**KIRKLEES METROPOLITAN COUNCIL
INVESTMENT & REGENERATION SERVICE**

Reference No:	2023/62/90630/W
Site Address:	53, Greenhead Road, Huddersfield, HD1 4ER
Description:	Erection of two storey extension
Recommending Officer:	Tom Hunt

DECISION – REFUSED

Officer Report

3D Rear

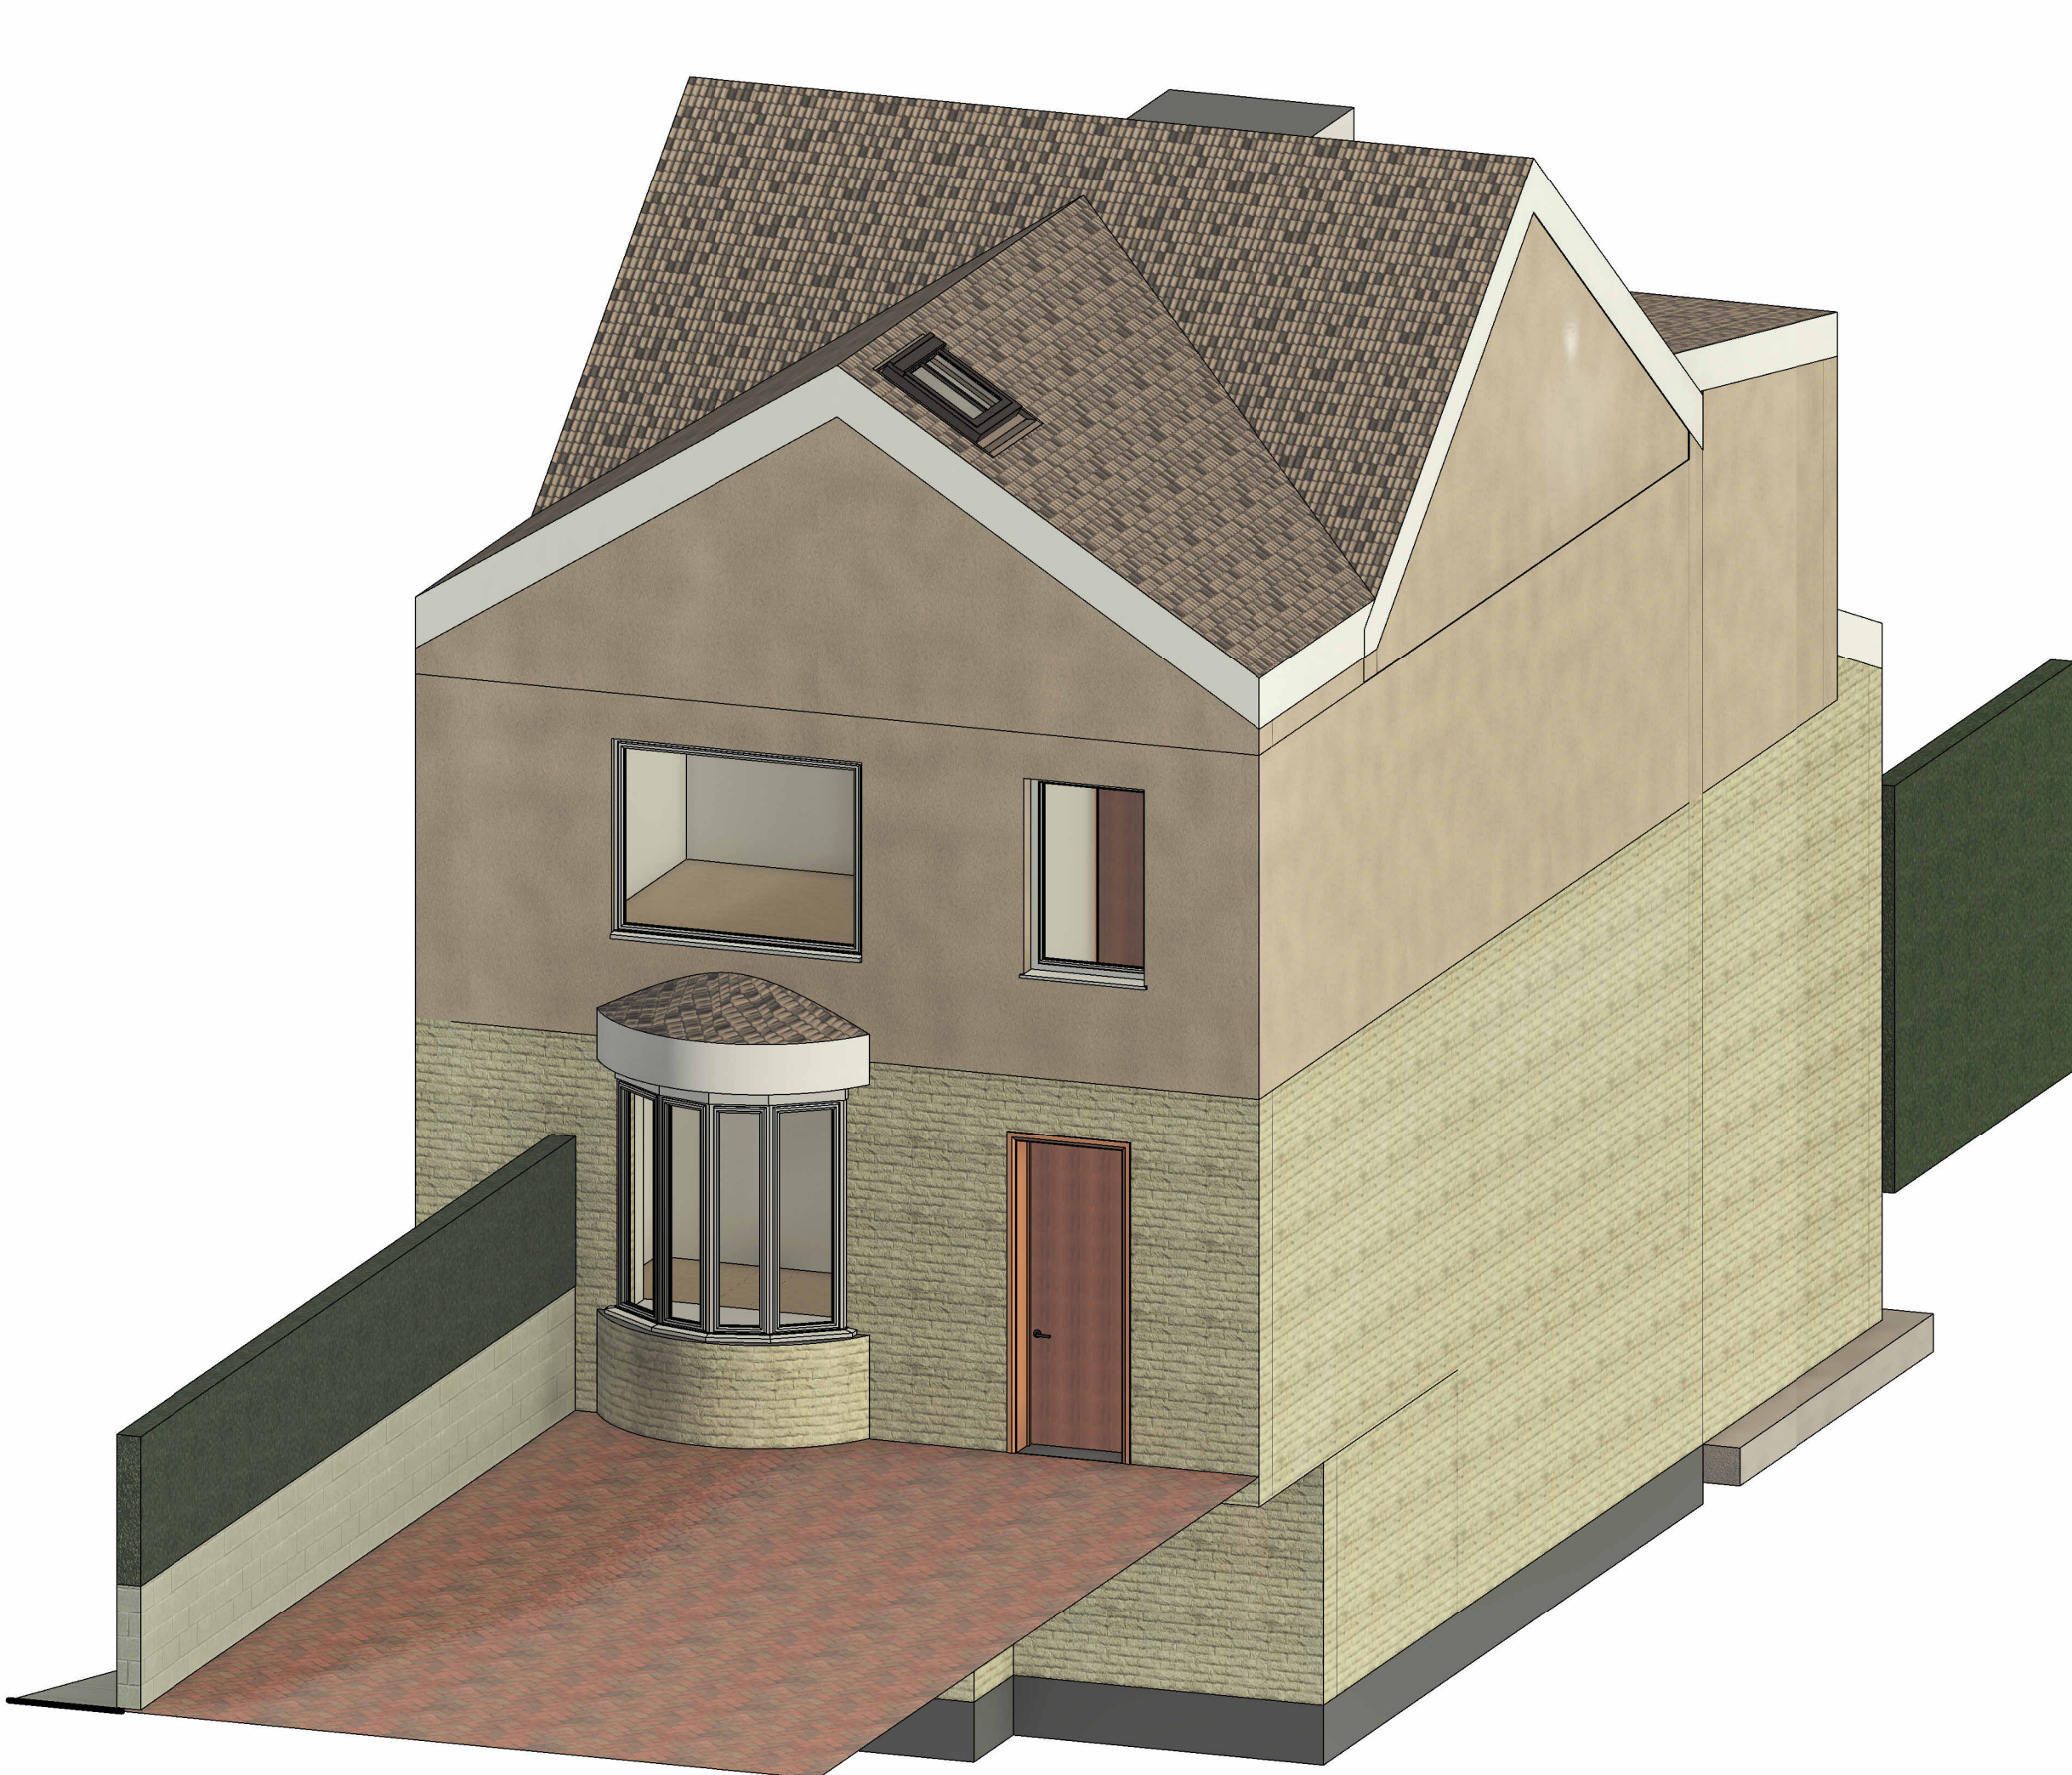
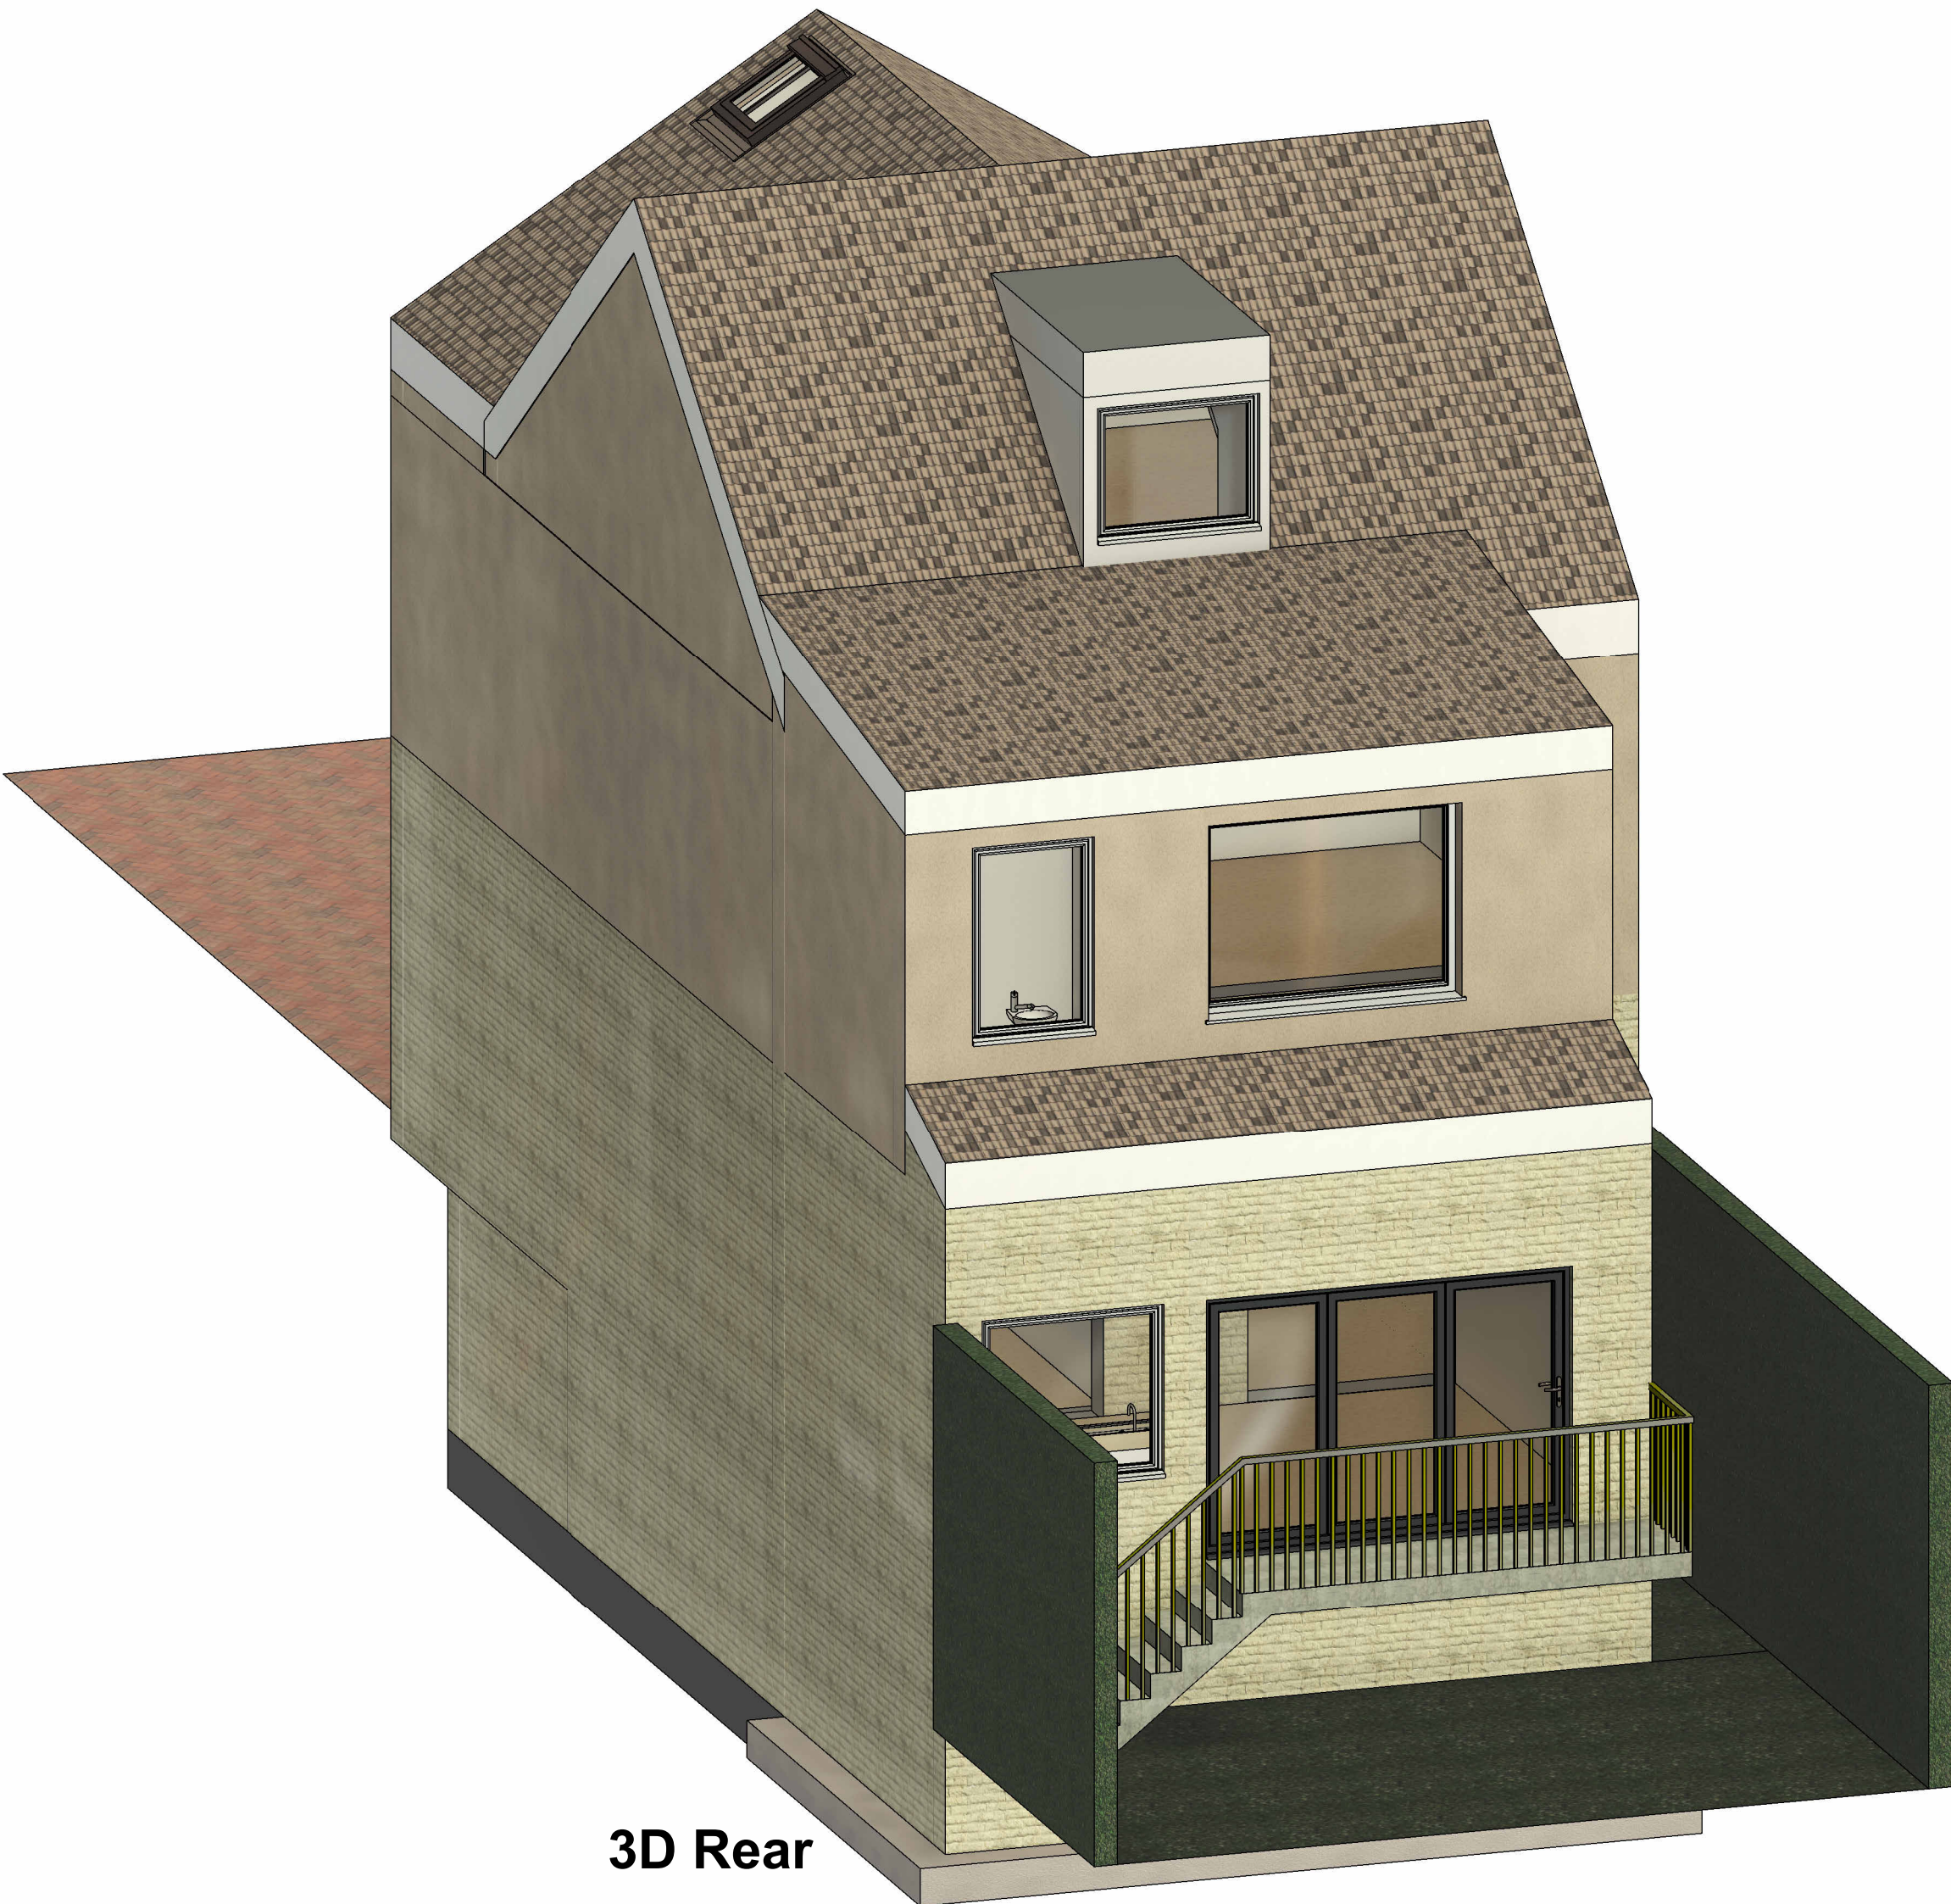
The work proposed would be to the rear of the property visible from Park Grove and would have a low-quality design of a two-storey rear extension made more prominent with an additional understorey base protruding out in the middle of a three property terraced row. It would appear excessively scaled and of an awkward design with the tiered storeys and their two lean-to roofs competing with the original design and character of the host property's cross gabled roof and mainly obscuring original elevations. Its roof would abut the existing rear dormer adding an obtrusive and discordant alien feature, failing to sympathetically integrate with its host, the character of the streetscene and the Conservation Area.

Overall, the design would appear to form a cramped building of significant massing and bulk within a constrained site and its small rear amenity space appearing to dominate its host and neighbours in a prominent setting easily viewed from Park Grove with the Conservation Area visible beyond when viewed from Park Road. It is considered the proposal would detract from the setting of the Conservation Area when viewed from this viewpoint given the design of the proposal and visual impact it is considered to have in relation to the host property / locality (discussed in more length in section 4 of this report).
